CITY OF ALBUQUERQUE

RE: **Penske Truck Leasing Addition**
1400 Candelaria NE
Grading and Drainage Plan
Engineer's Stamp Date 10/9/17 (File: H15D052)

Based on the information provided in your submittal received on 10/10/17, this plan is approved for Building Permit with the following recommendation:

PERFORATED PIPE SECTION
SCALE: 1" = 1' - 0"

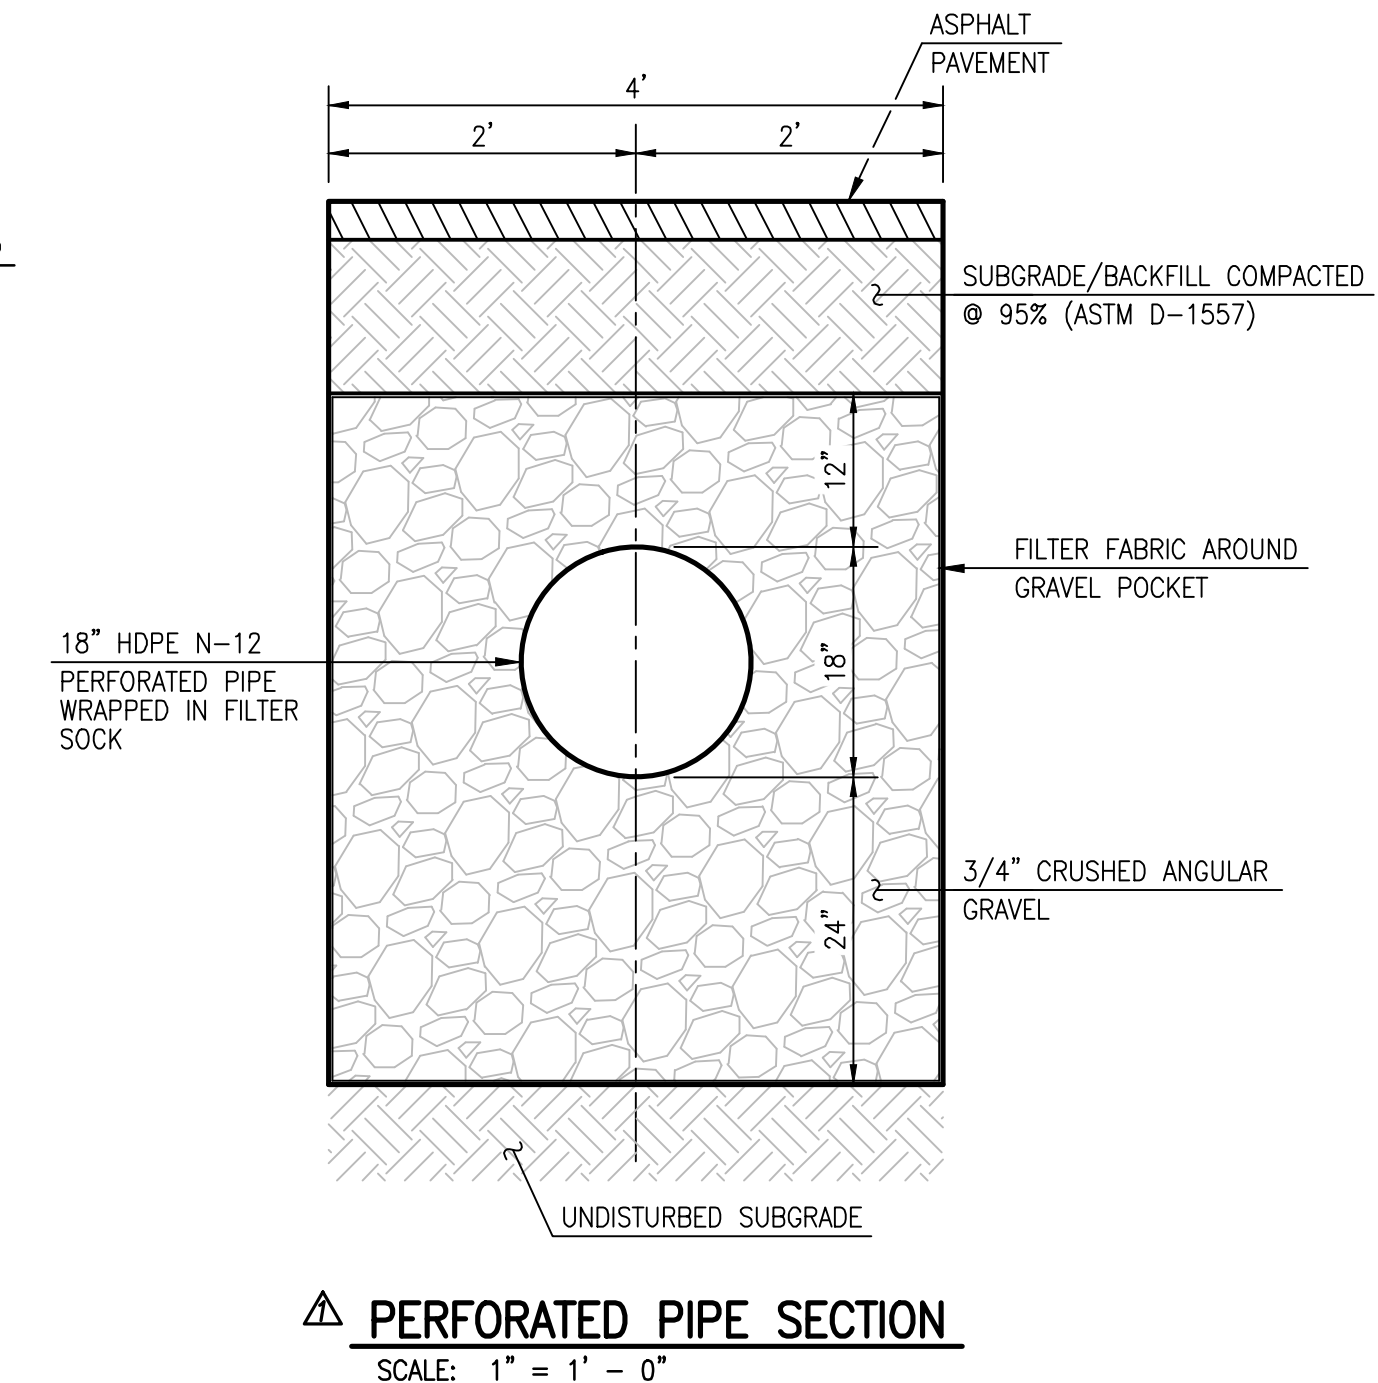
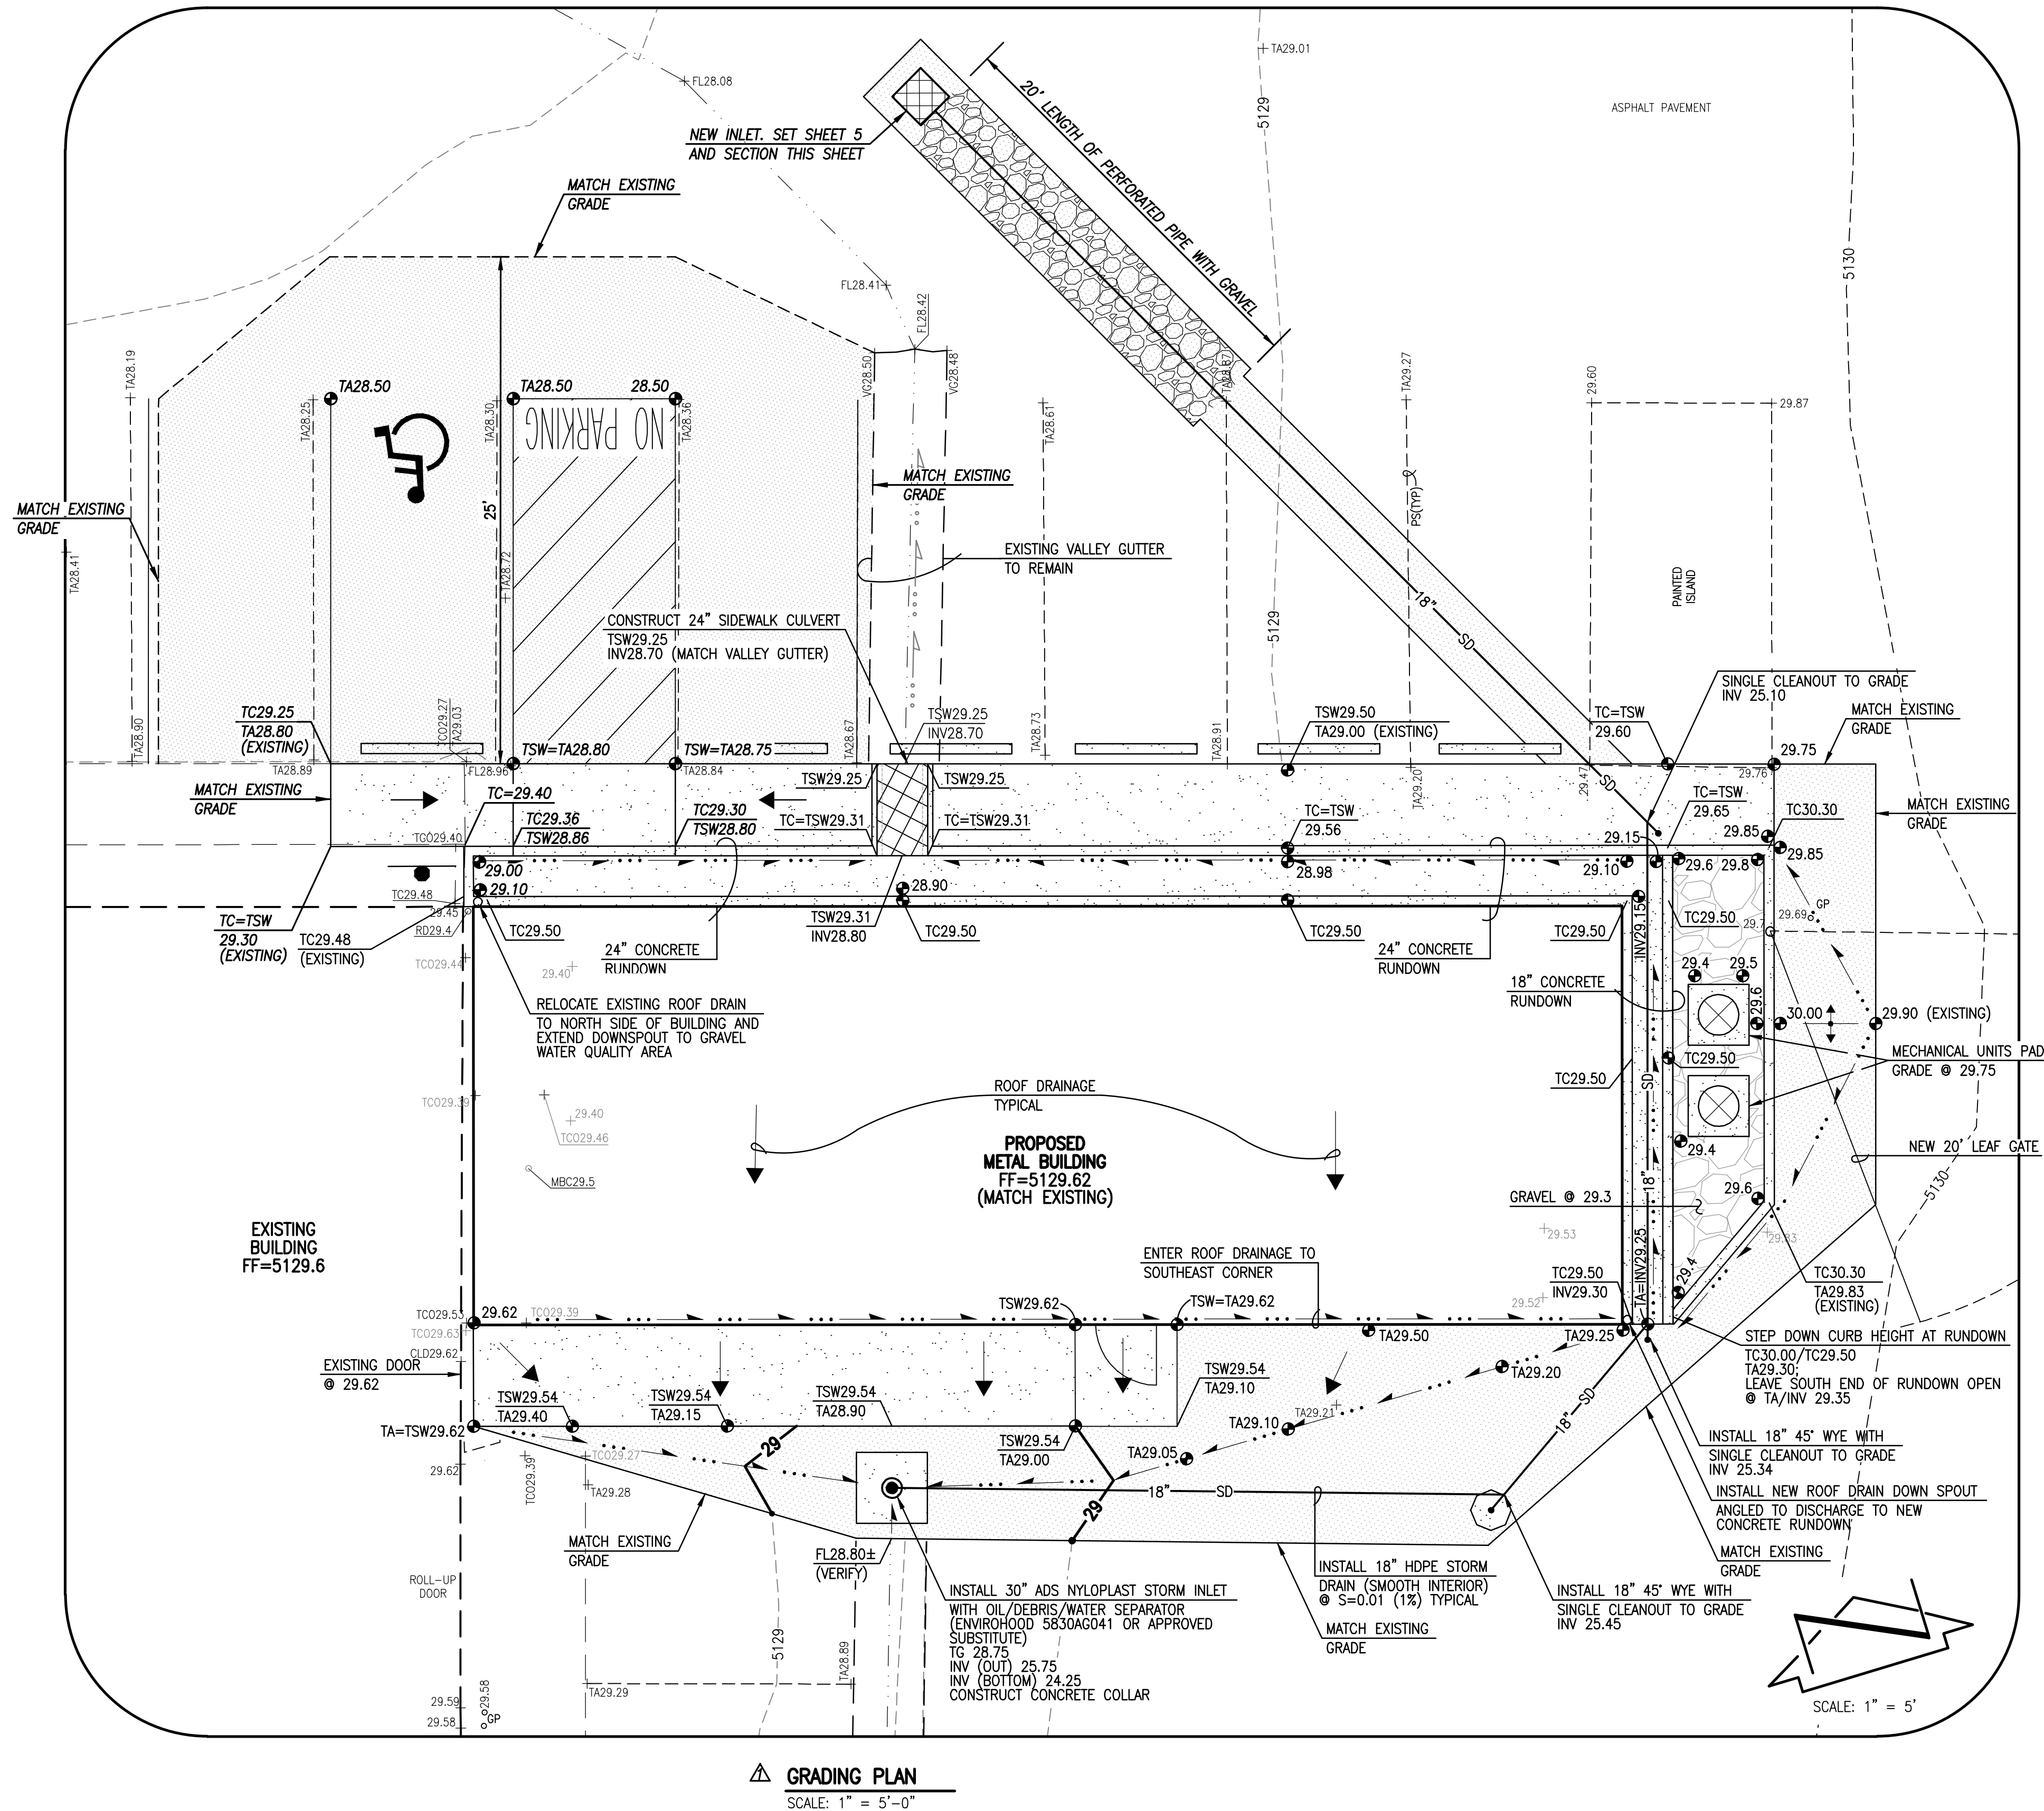
1. Perforate the pipe and add gravel bedding to allow the stormdrain to dewater.
